2023/0551

98 Upper Hoyland Road, Hoyland, Barnsley, S74 9NL

Two storey extension to rear of dwelling

REVISION:
TITLE
PLANS AS PROPOSED

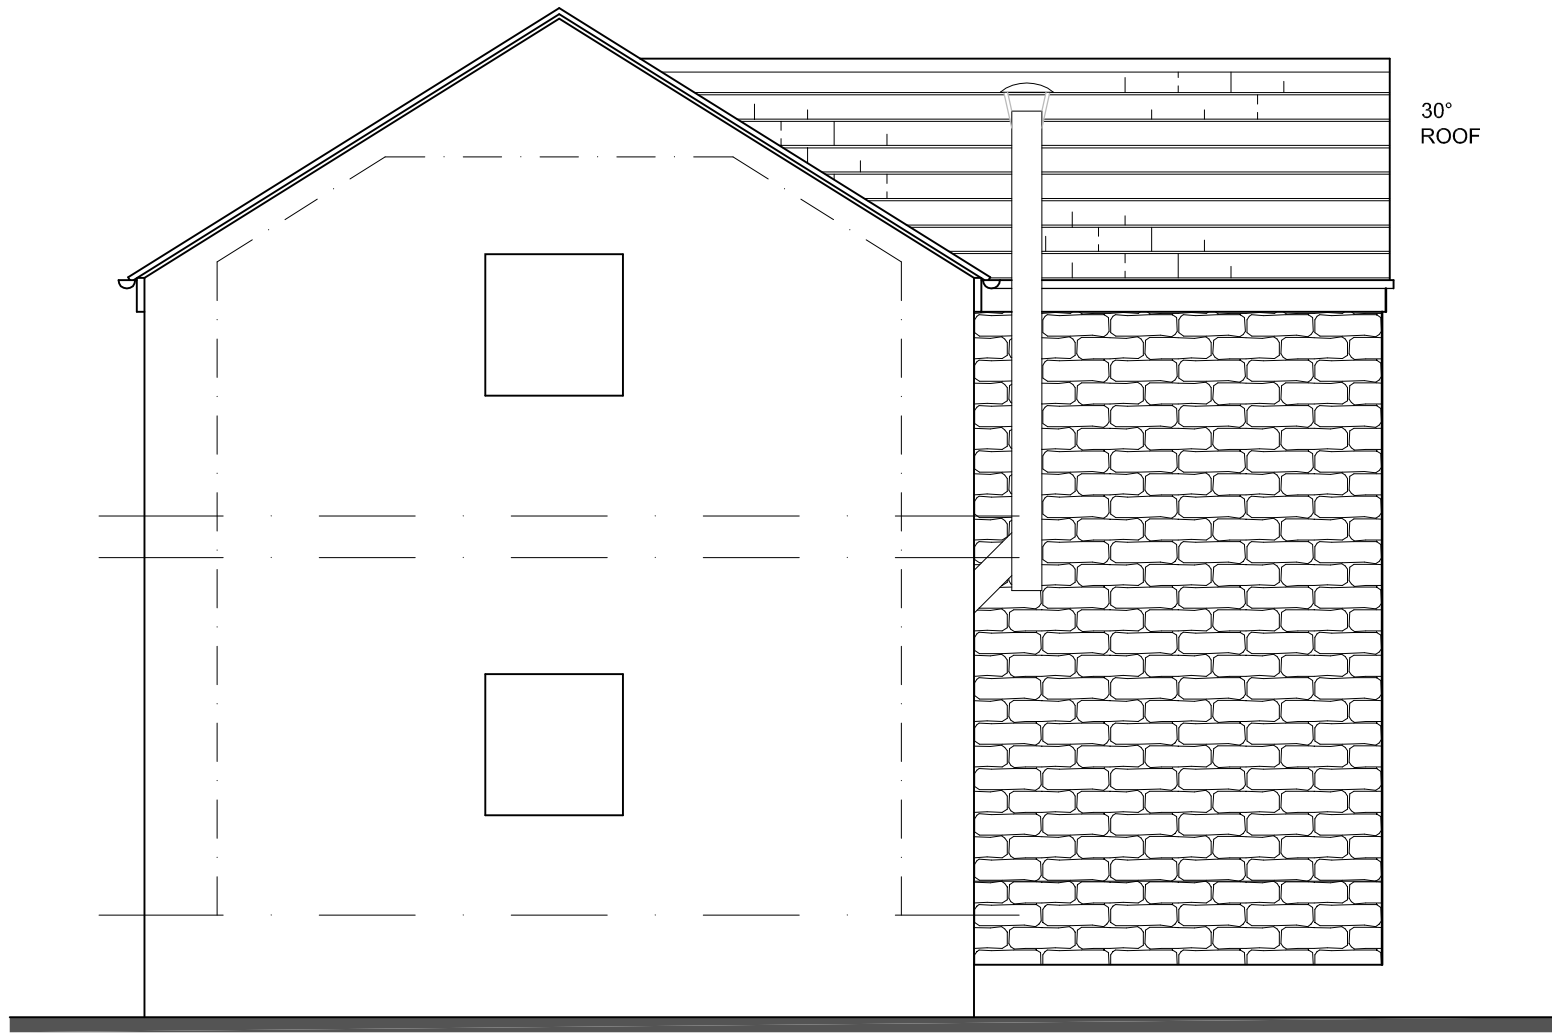
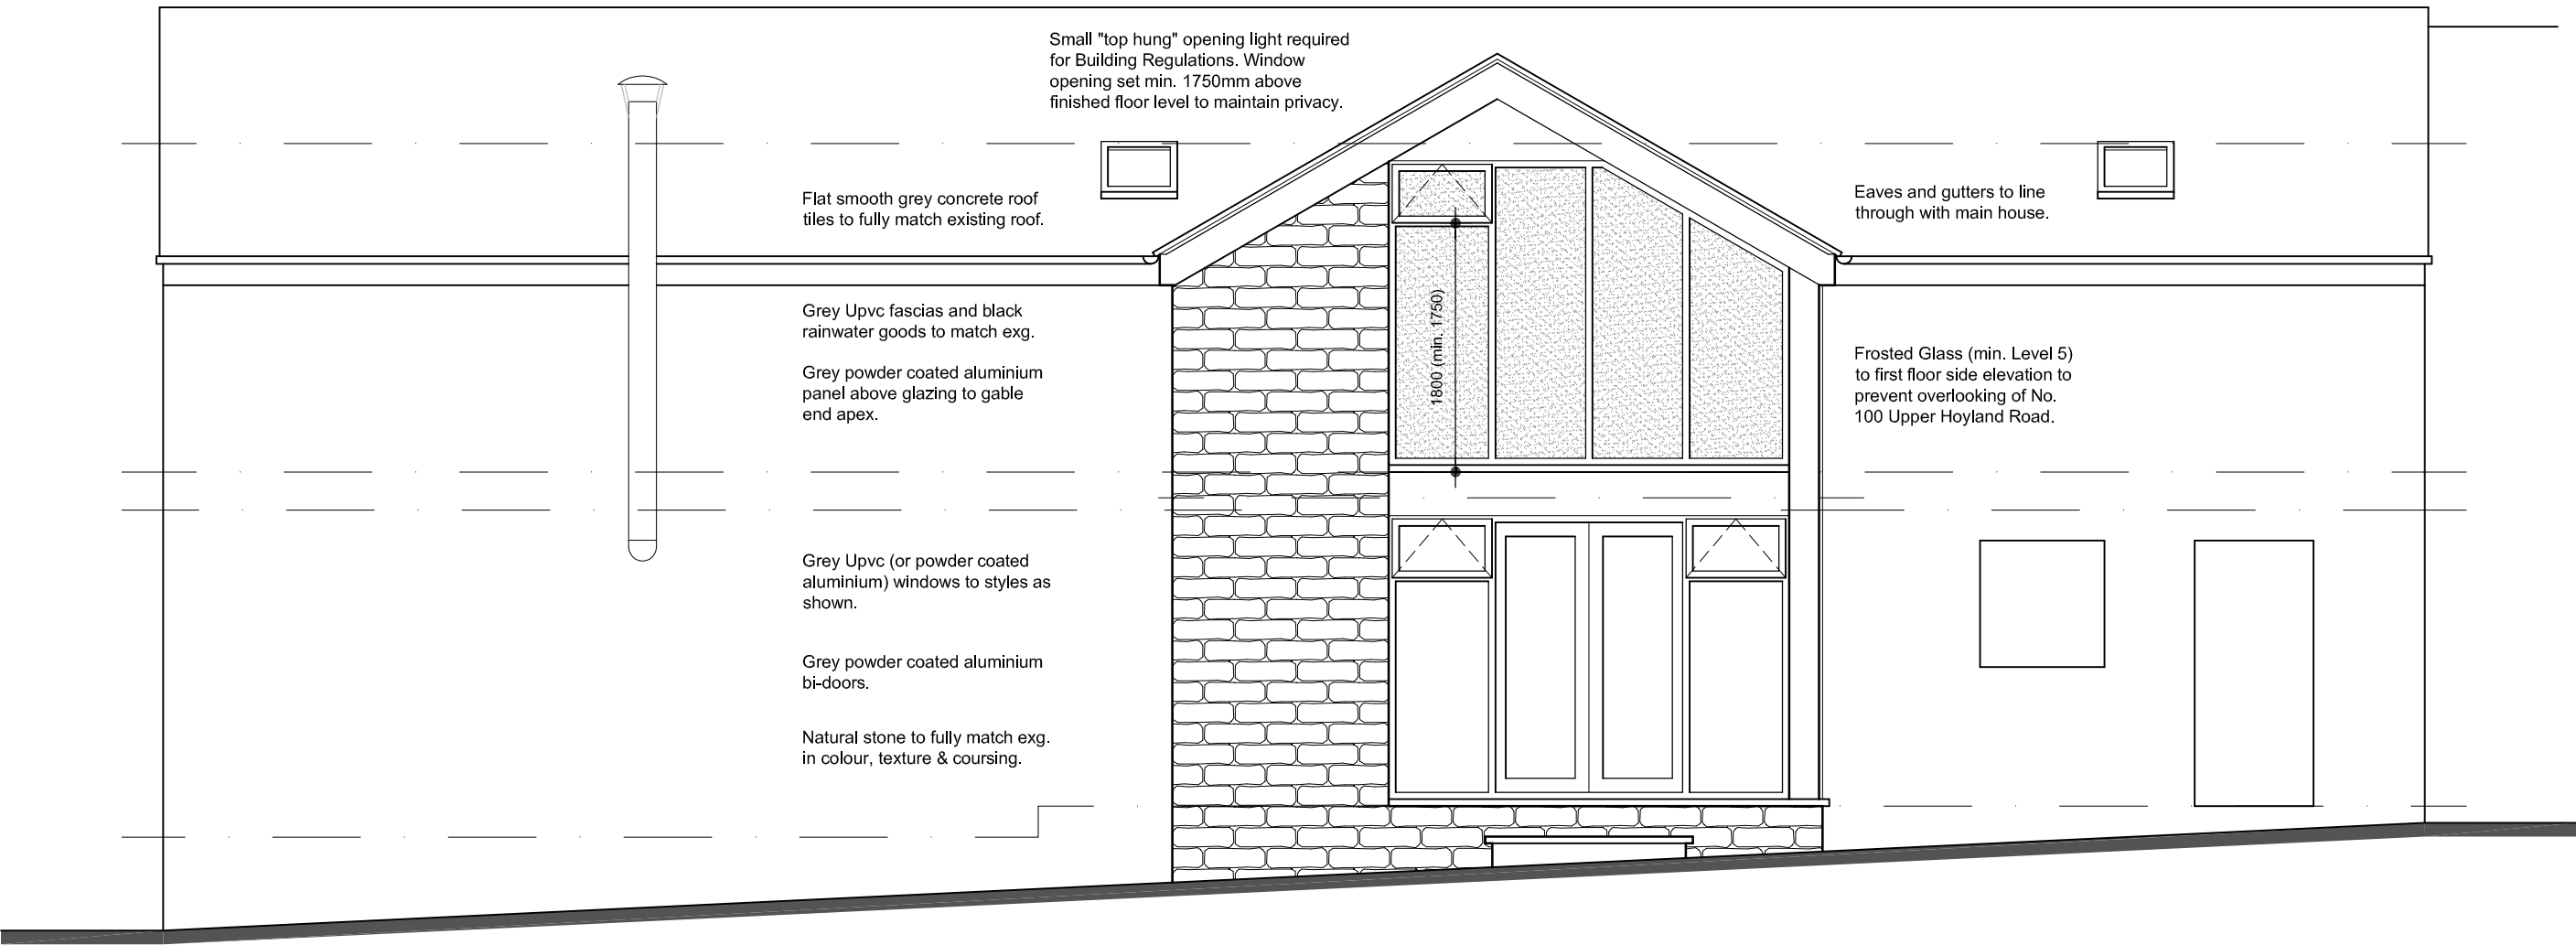
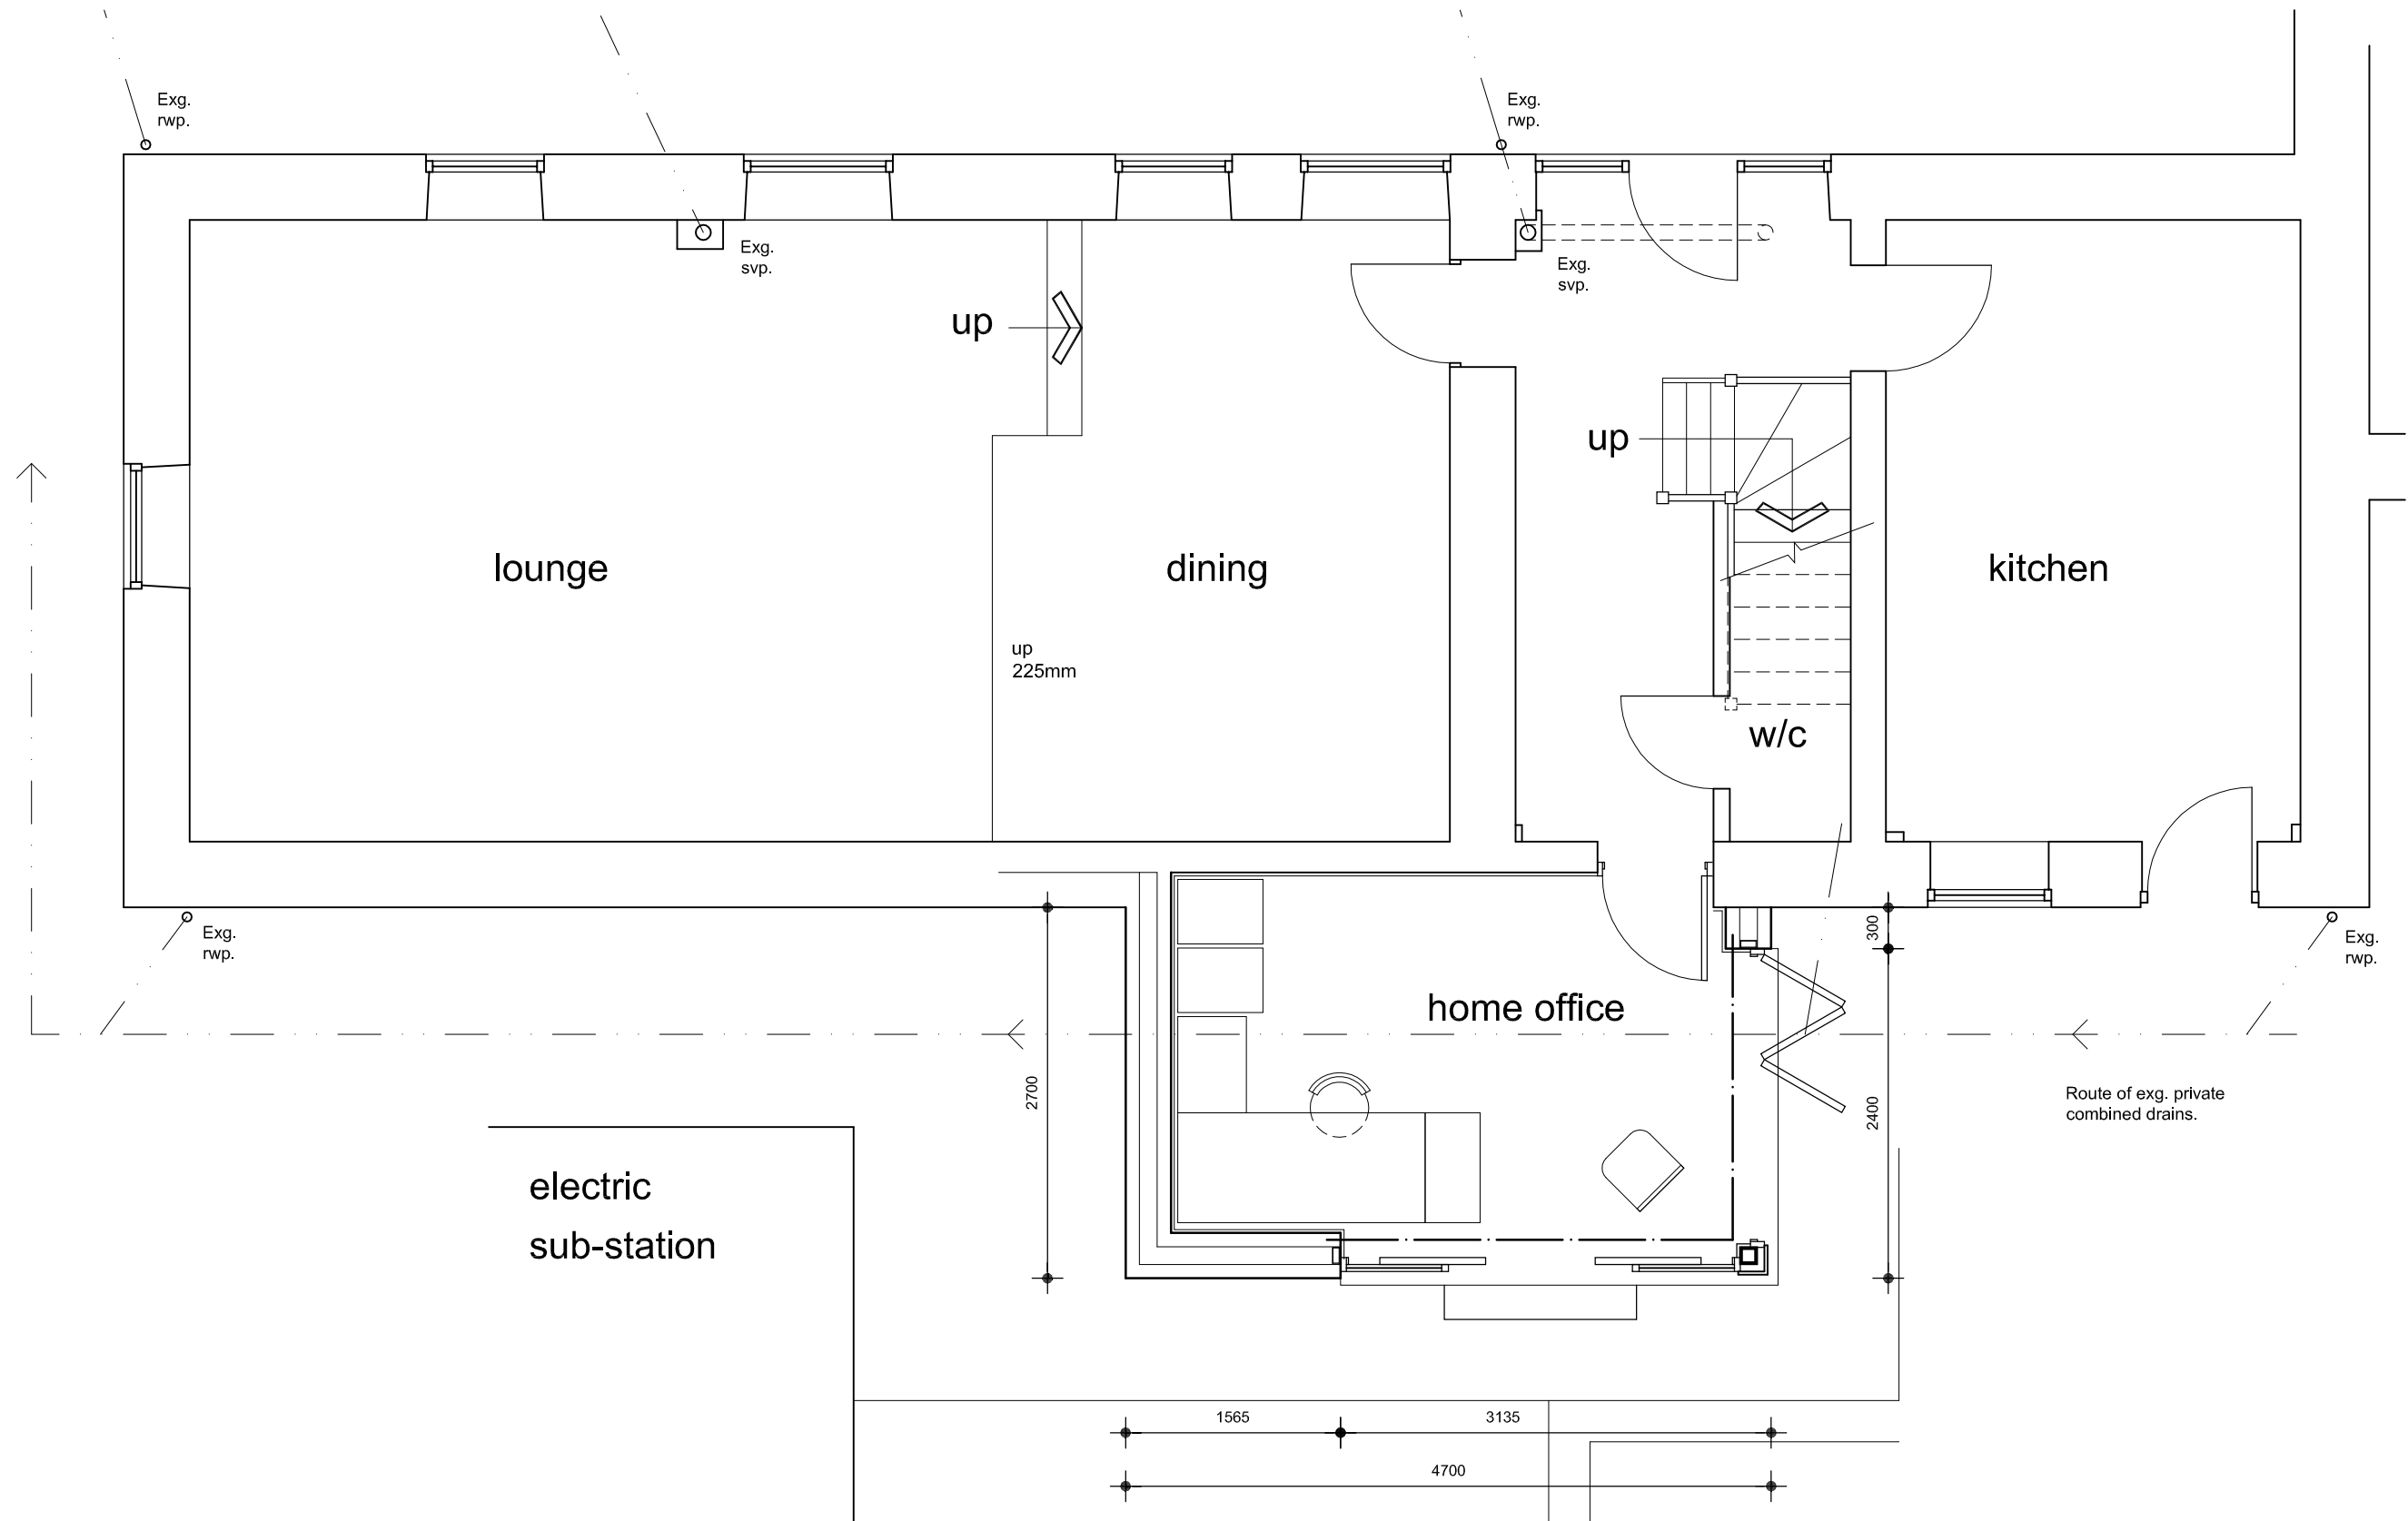
Amended proposals were received 18/07/2023 offering improvements, including a slight reduction in the total height of the extension, changes to external materials, and the inclusion of privacy glazing to some first-floor windows.

In this instance, the proposed extension would be of two-storeys and would maintain approximately 5.3 metres between the rear-facing first floor windows of the extension and the rear boundary. As such, the proposals would not meet the guidance of the SPD.

The windows located on the rear elevation of the proposed extension would face adjacent neighbouring property 100 Upper Hoyland Road. It is acknowledged that there could be some increased overlooking from the first-floor windows due to slight topography differences; however, due to the positioning of the applicant dwelling within the building line, views would generally be directed towards the side elevation of 100 Upper Hoyland Road where secondary windows are not offered the same protections as those serving habitable rooms on the front and rear elevations of the property. Some mitigation is likely to be offered from the screening created by existing projections, extensions, and outbuildings, and further mitigation would be offered by the proposals due to the inclusion of privacy glazing (level 5) to the first-floor rear-facing windows.

In this instance, the proposed extension would use external materials that partially matched those used in the construction of the main dwelling, including natural stone and grey concrete roof tiles. Other external materials to be used include grey powder coated aluminium panelling, doors, and windows. The proposed extension would also feature an apex roof that would reflect the style and pitch of the roof of the main dwelling.
